PR-2021-005904

SD-2023-00230 – PRELIMINARY/FINAL PLAT

Development Facilitation Team (DFT) – Review Comments

Planning - Case Comments

**Plat for
 Lot 27-A, Block 10
 Original Townsite of Westland
 Being Comprised of
 Remaining Portions of Lots 24 thru 27,
 Block 10, Original Townsite of Westland
 and Vacated 10ft Alleyway
 City of Albuquerque, Bernalillo County, New Mexico
 November 2023**

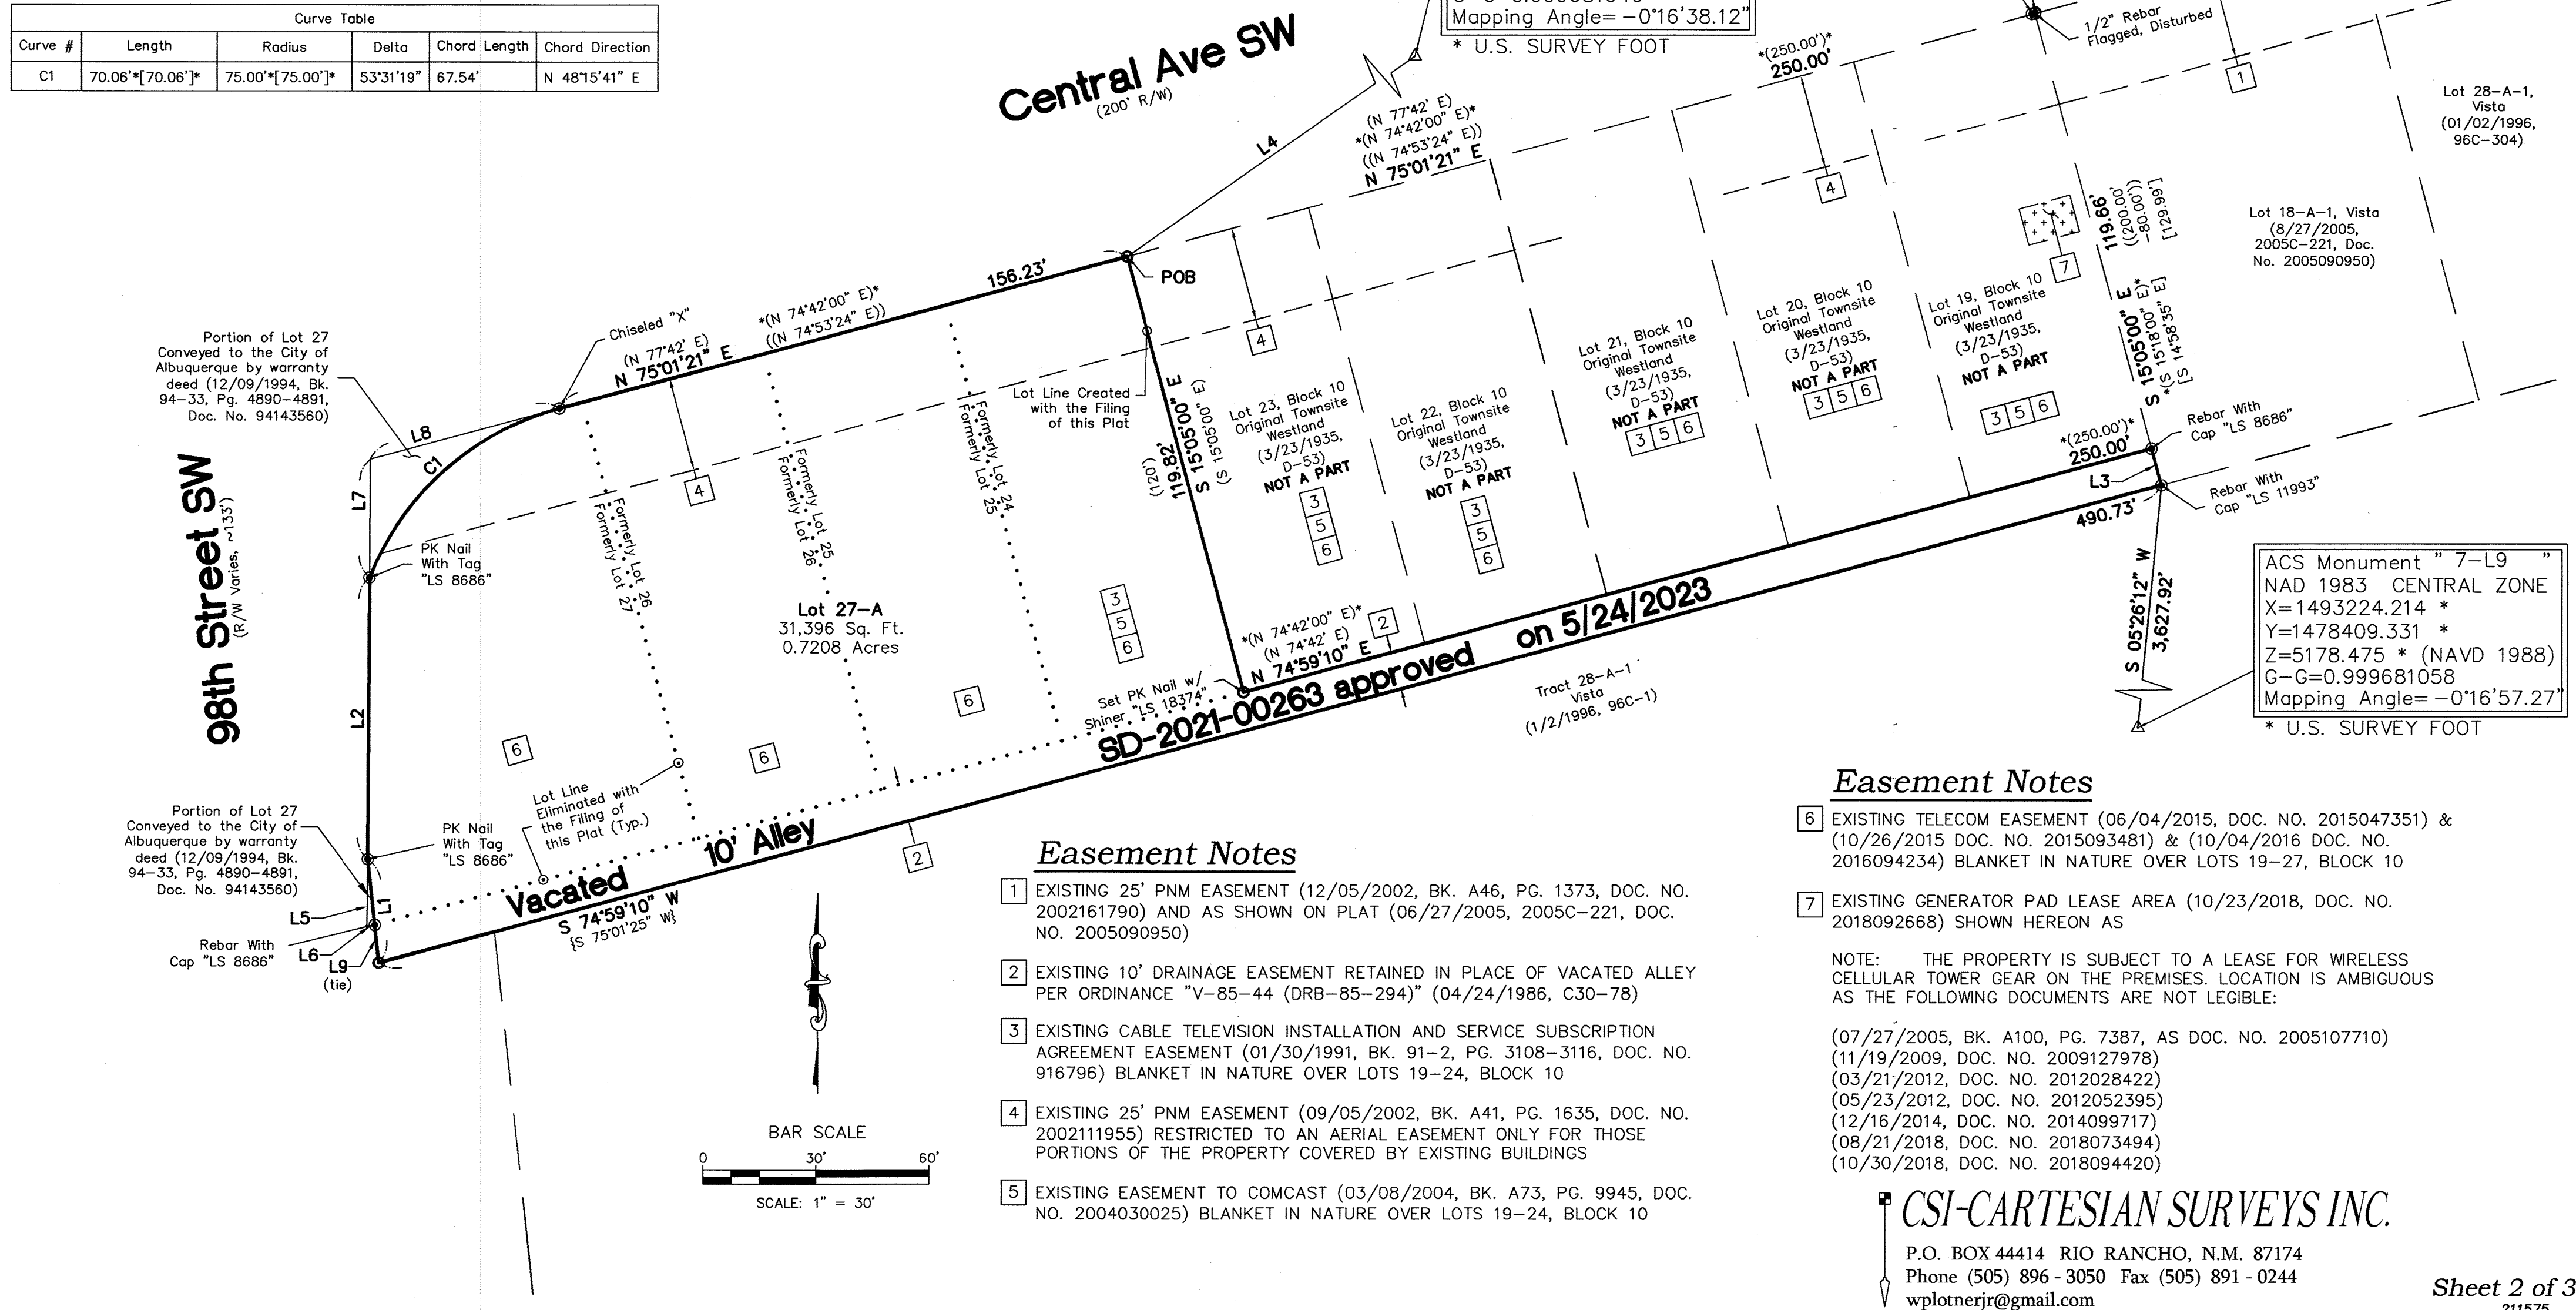
- The Plat was signed by Diana Cordova, trustee for the Dominica M. Moya trust. Documentation must be provided confirming Ms. Cordova as the trustee.
- The project number must be corrected to PR-2021-005904, and the application number must be added to the Plat prior to final sign-off by DFT staff, should the Plat be approved by the DHO.

- The City's AGIS office must approve the DXF file for the Plat prior to the final sign-off of the Plat, should the Plat be approved by the DHO.
- As the Plat would be incorporating vacated right-of-way, the City's Real Property Division must sign the Plat (after the DFT staff the Plat and before the City Engineer provides final sign-off). Therefore, a signature line for Real Property must be added to the Plat.
